**RESPONSE TO SUBMISSIONS (RTS)
EDEN STREET MIXED USE REDEVELOPMENT (SSD-11429726)
26-42 EDEN STREET AND 161-179 PRINCES HIGHWAY, ARNCLIFFE**

Thank you for referring the 'Response to Submissions' (RtS) to Transport for NSW (TfNSW) regarding SSD-11429726 'Eden Street Mixed Use Redevelopment'.

TfNSW has reviewed the RtS and provides the following comments for consideration and suggested conditions of consent in **TAB A**.

2 PRINCES HIGHWAY RAMP - SECTION A  
1:100

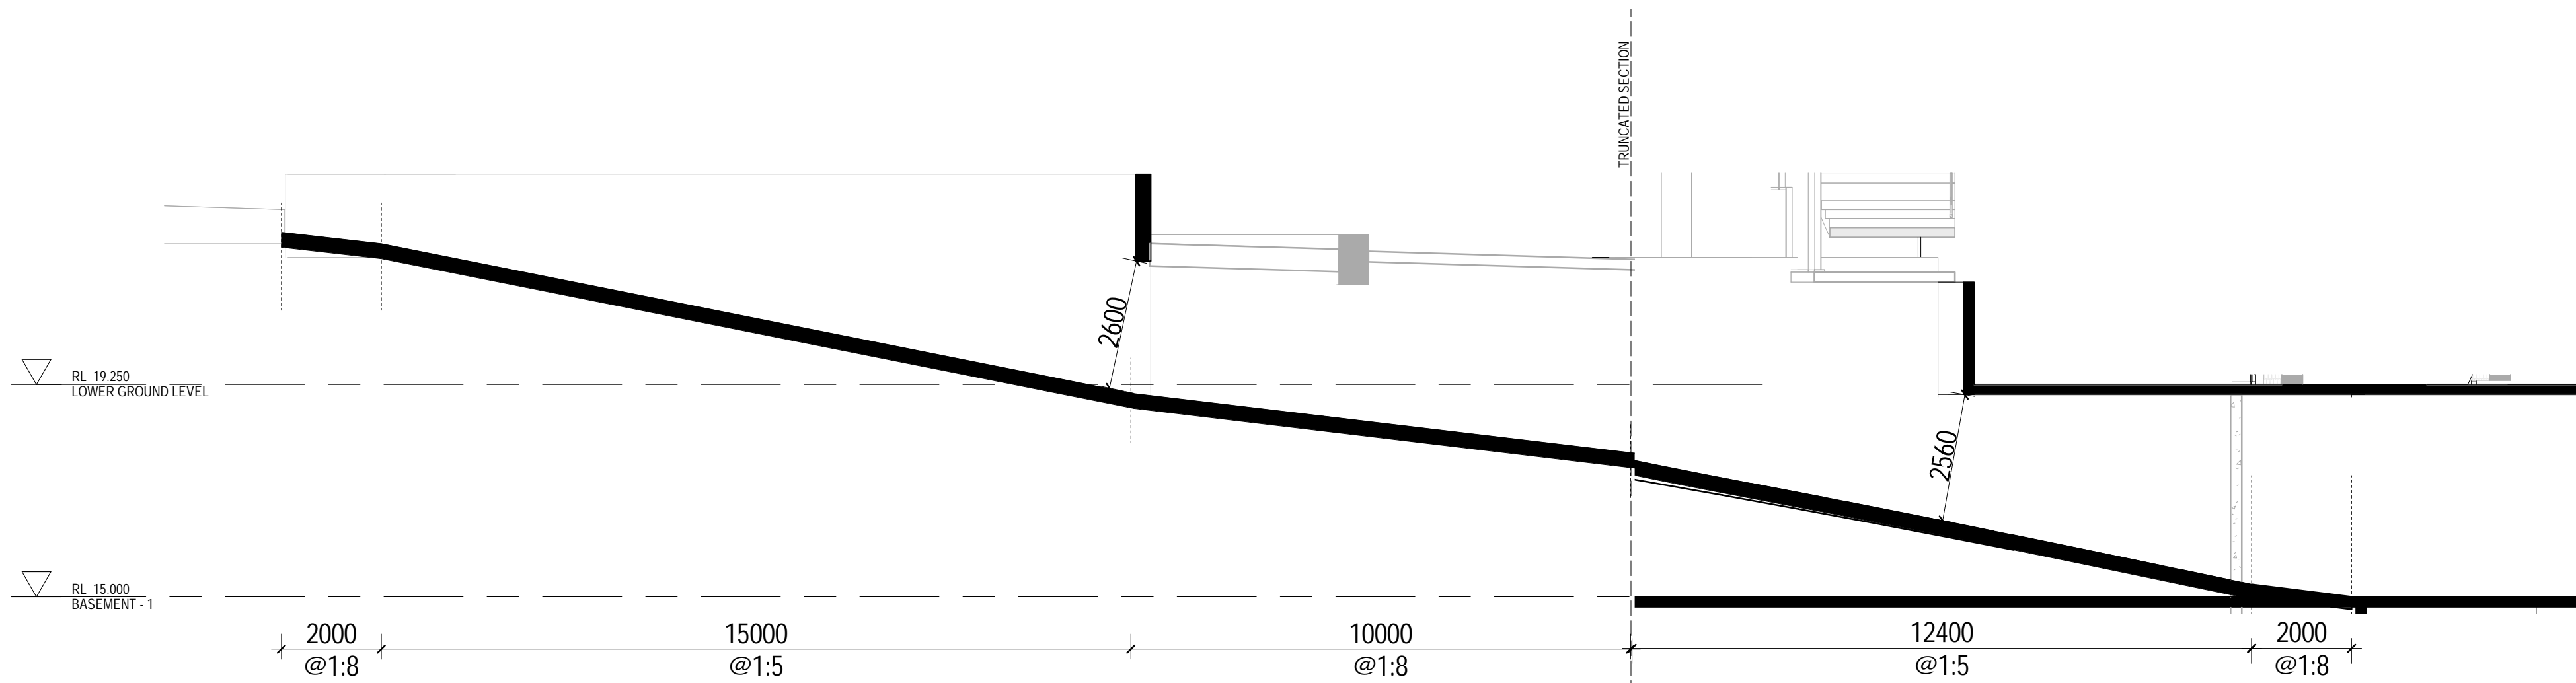
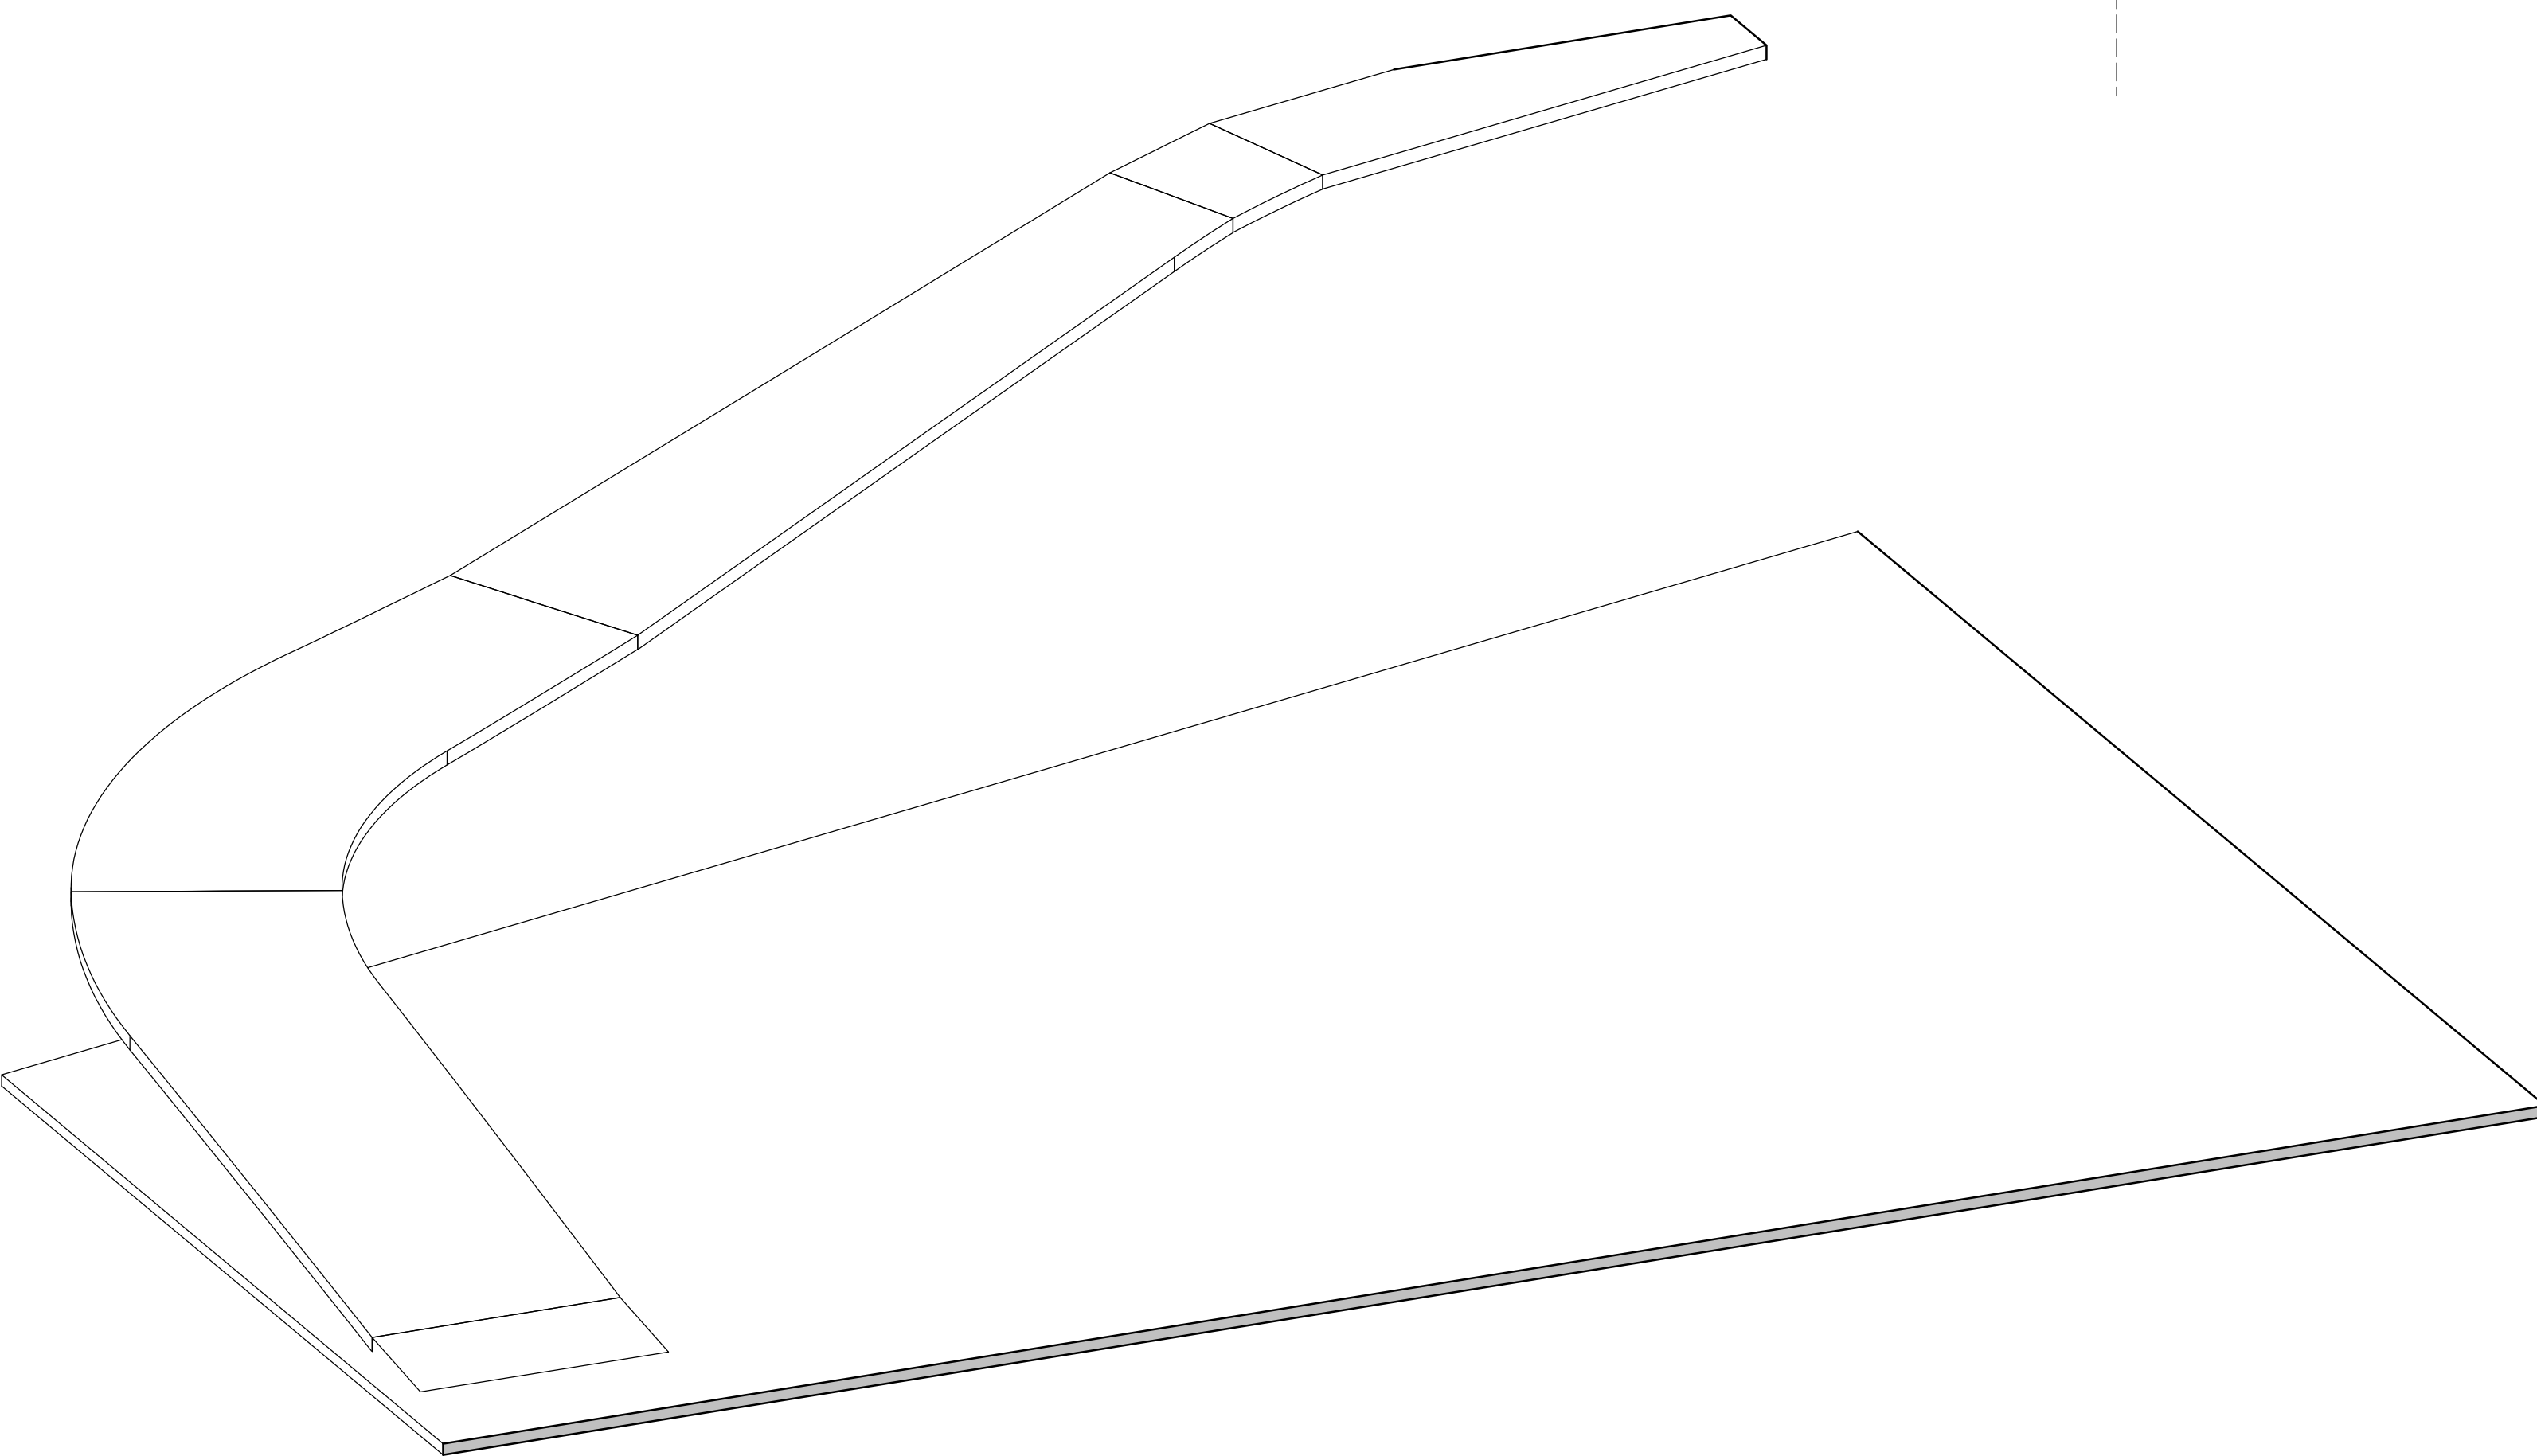
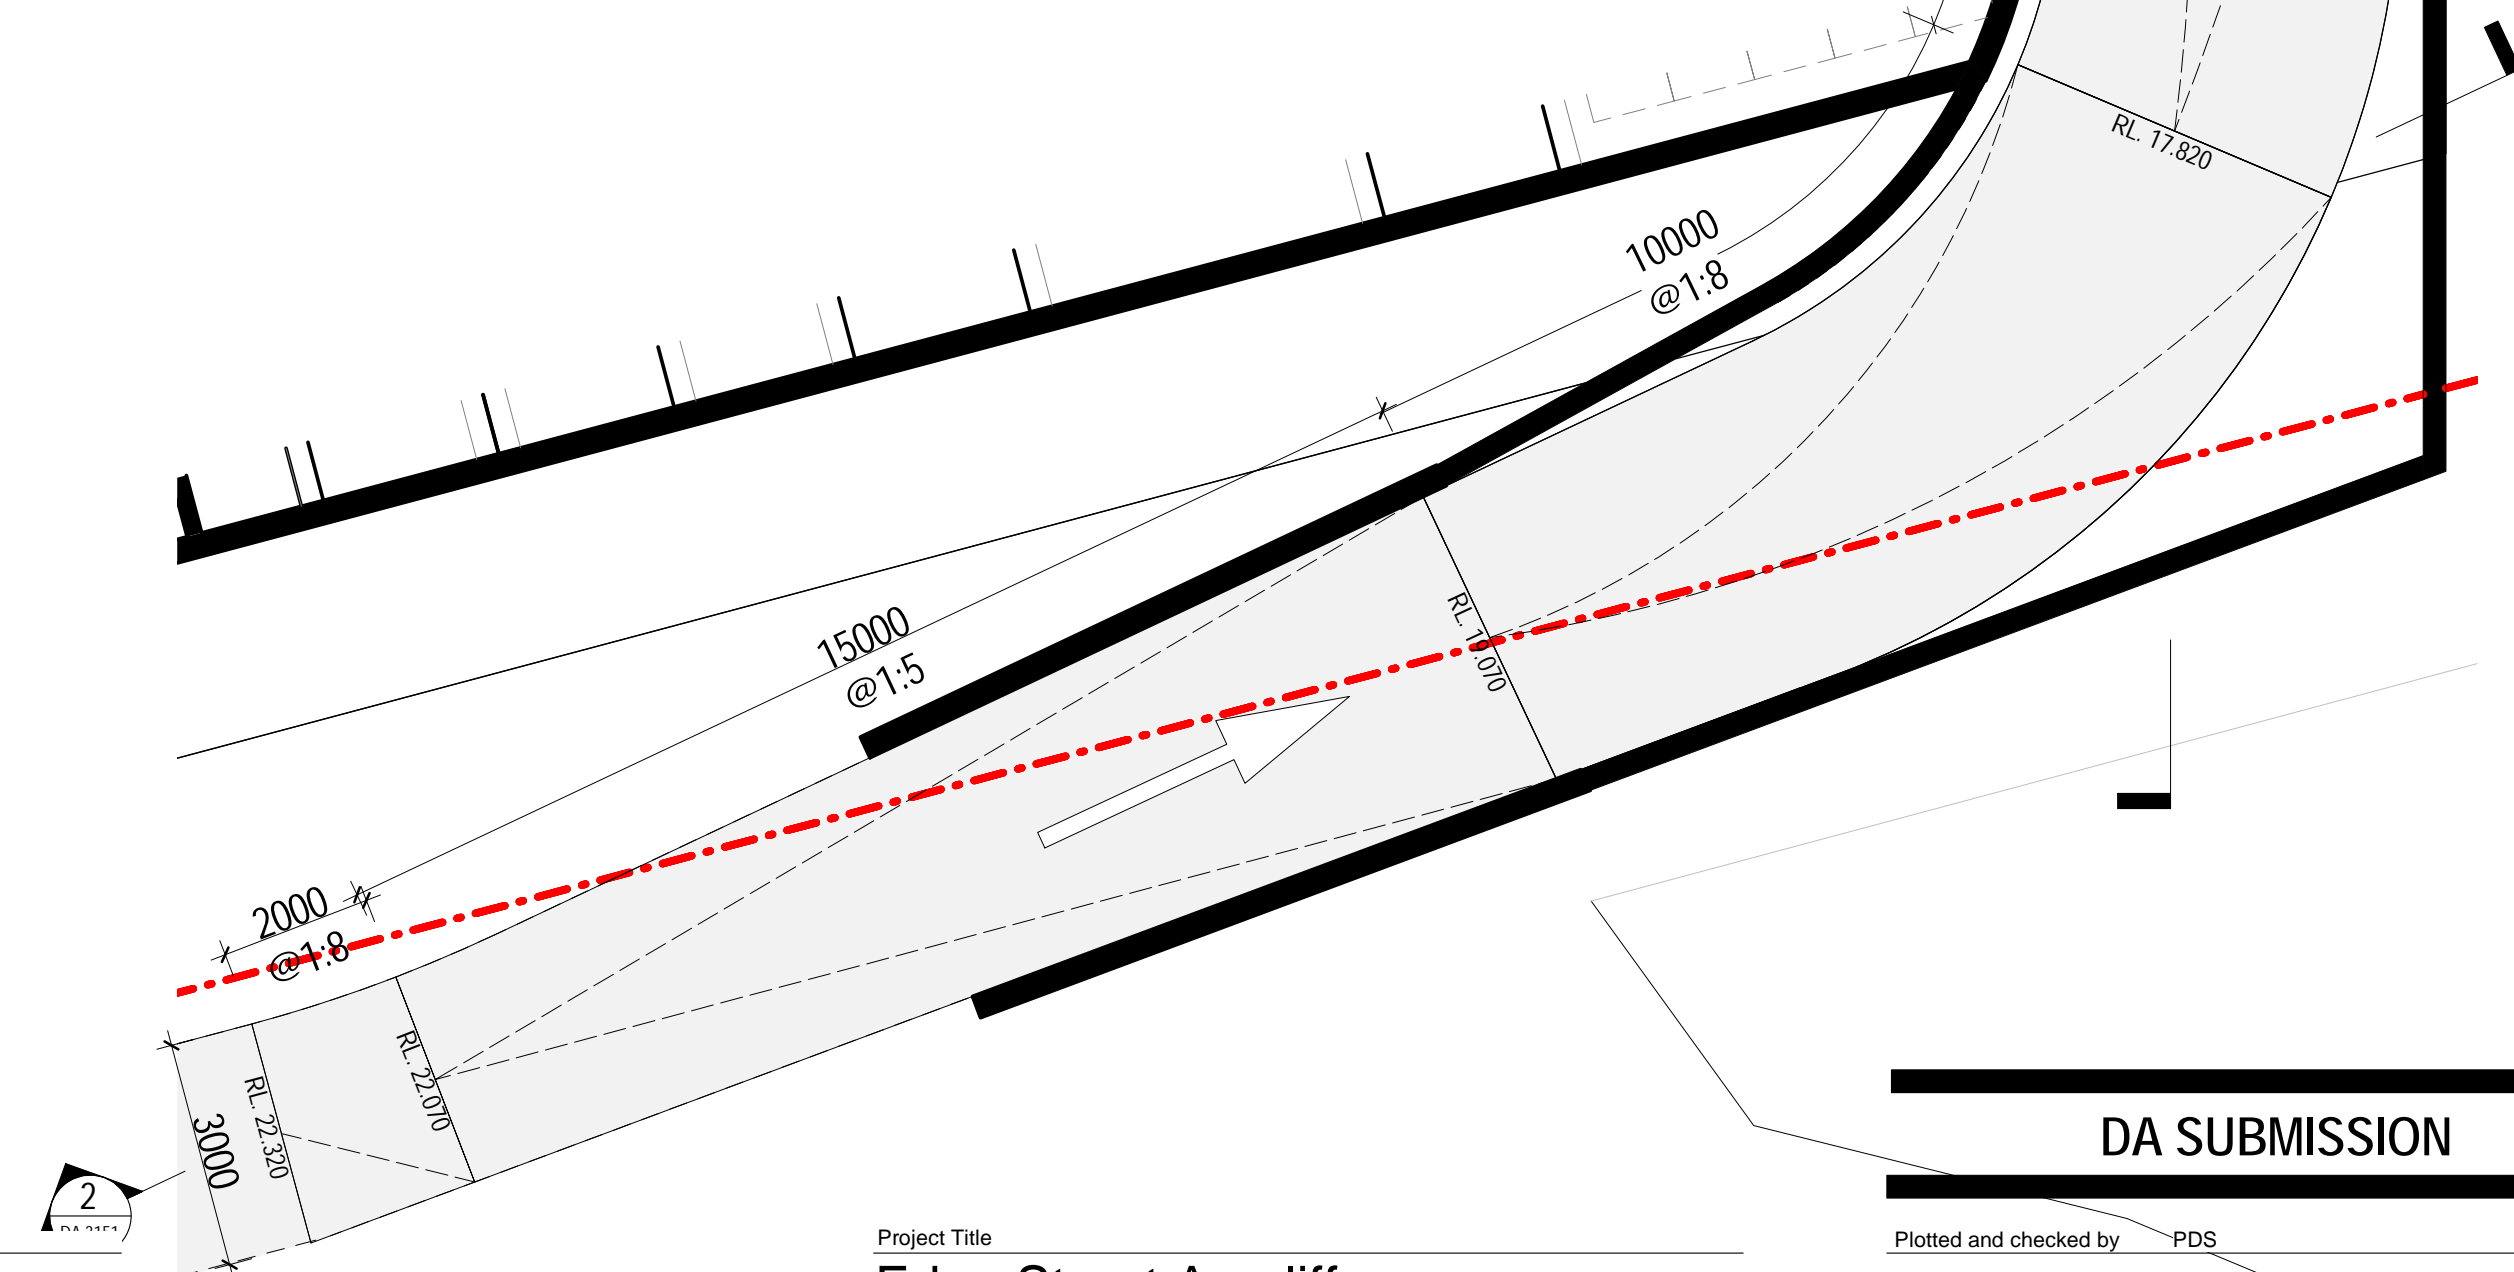
TfNSW support's 'in-principle, the proposed deceleration lane and associated supporting civil works, as a 'left-in only' arrangement from the Princes Highway to the subject development.

- Capacity / length of deceleration lane to be modelled in SIDRA with the existing tidal flow on Princes Highway and its operation and if there is a traffic overflow to Princes Highway, mitigation options to be developed. Electronic copy of SIDRA should accompany the submission.

- Deceleration lane need to be suitable for a 70km/h design speed and designed as per Austroads Part 4A.
- There would need to be a distance equal to 4 secs of travel between the left turn lane from Forest Road onto the Princes Highway and the start of the deceleration lane.

- The design of the deceleration lane and the following ramp into the car park would need to consider the grade (and therefore the length) of the ramp, vertical clearance at the portal, the size of vehicles accessing the car park and the appropriate sight distance over the crest where the deceleration lane ends and the ramp starts.

- Assess the required width and the length for the deceleration lane and the ramp when offsets, grades etc are taken into consideration.
- Independent Road Safety Audit (RSA) is to be undertaken for the deceleration lane concept design including the proposed grade separation of deceleration lane and pedestrian's path / movement with any recommendations incorporated into the concept design.

- Prior to the issue of any construction certificate, the Applicant shall obtain concurrence under section 138 of the *Roads Act 1993* and enter a WAD for the civil works on Princes Highway.
